**OBJECTION**

**State Significant Development Application No: SSD-10300**

**Coffs Harbour Cultural and Civic Space**

SECTION N-S

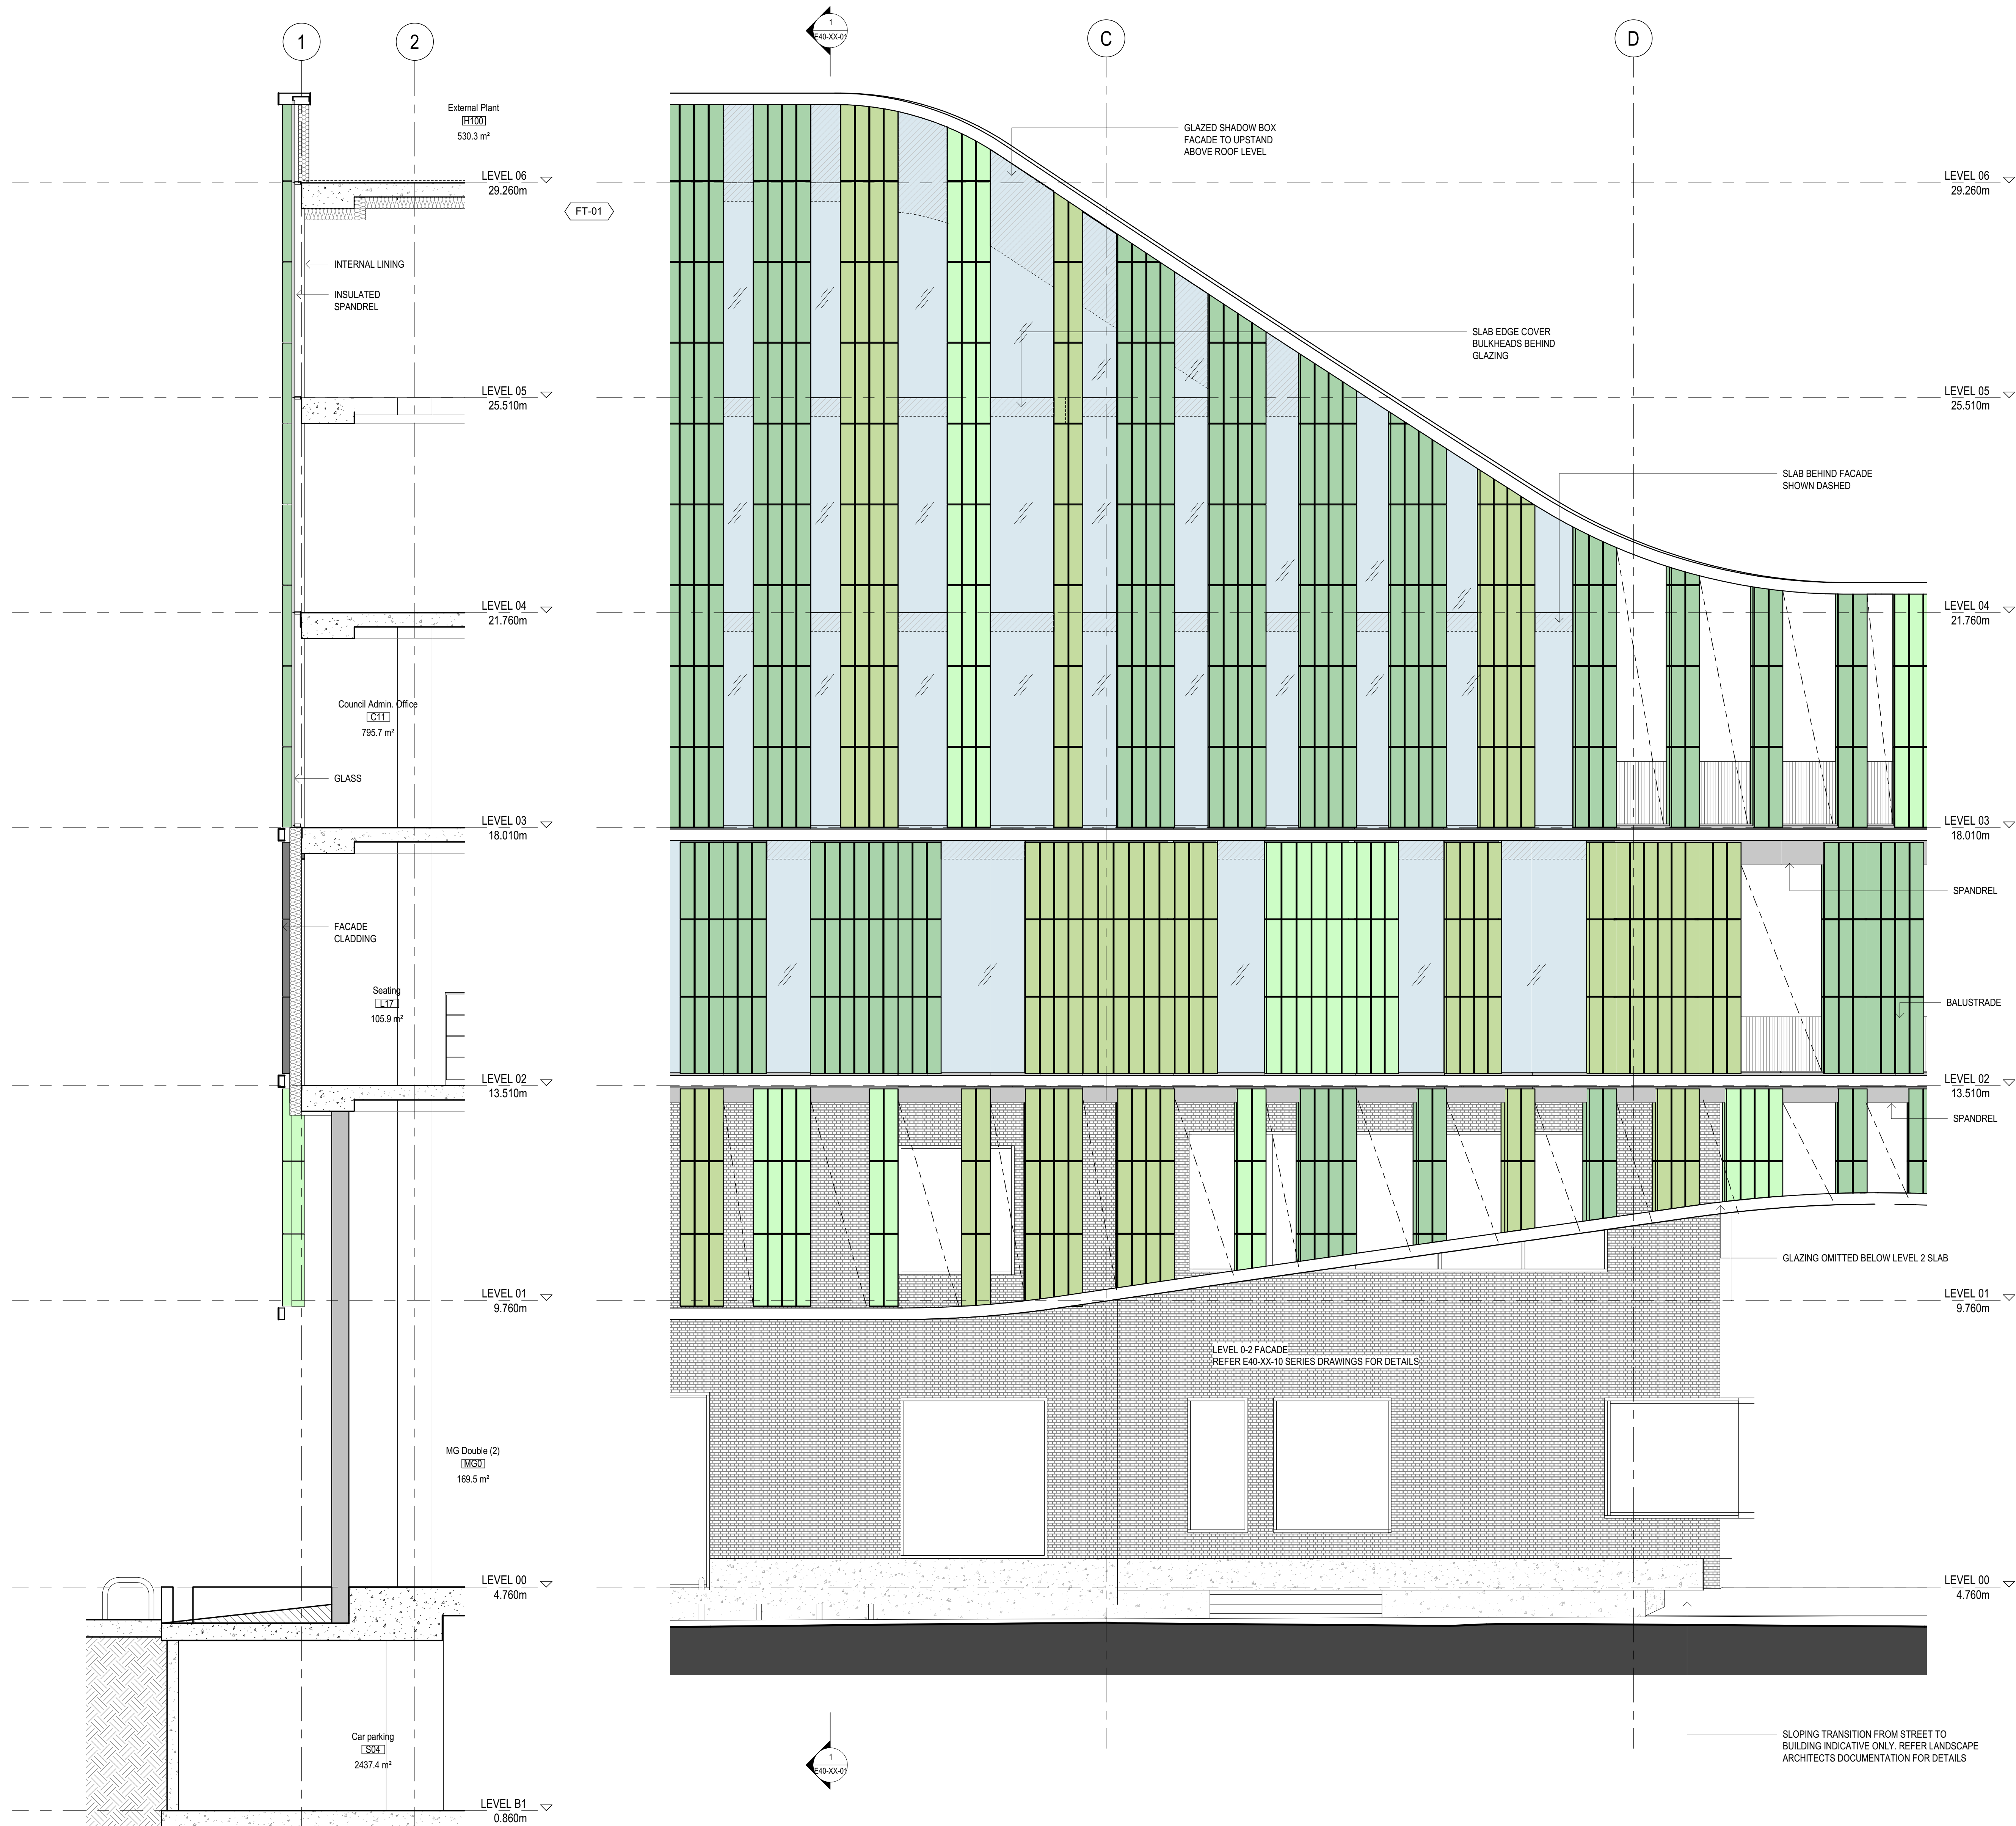
7. As a public building it fails to provide sufficient climate protection for pedestrians during storms and summer sun.
8. The building exceeds the height restriction of 28m set down in Council's own planning controls. Council's argument for variation is not satisfactorily justified and is not consistent with the objectives of the Environmental Planning and Assessment Act 1979, which requires the "the orderly and economic use and development of land". Council should not receive preferential treatment.
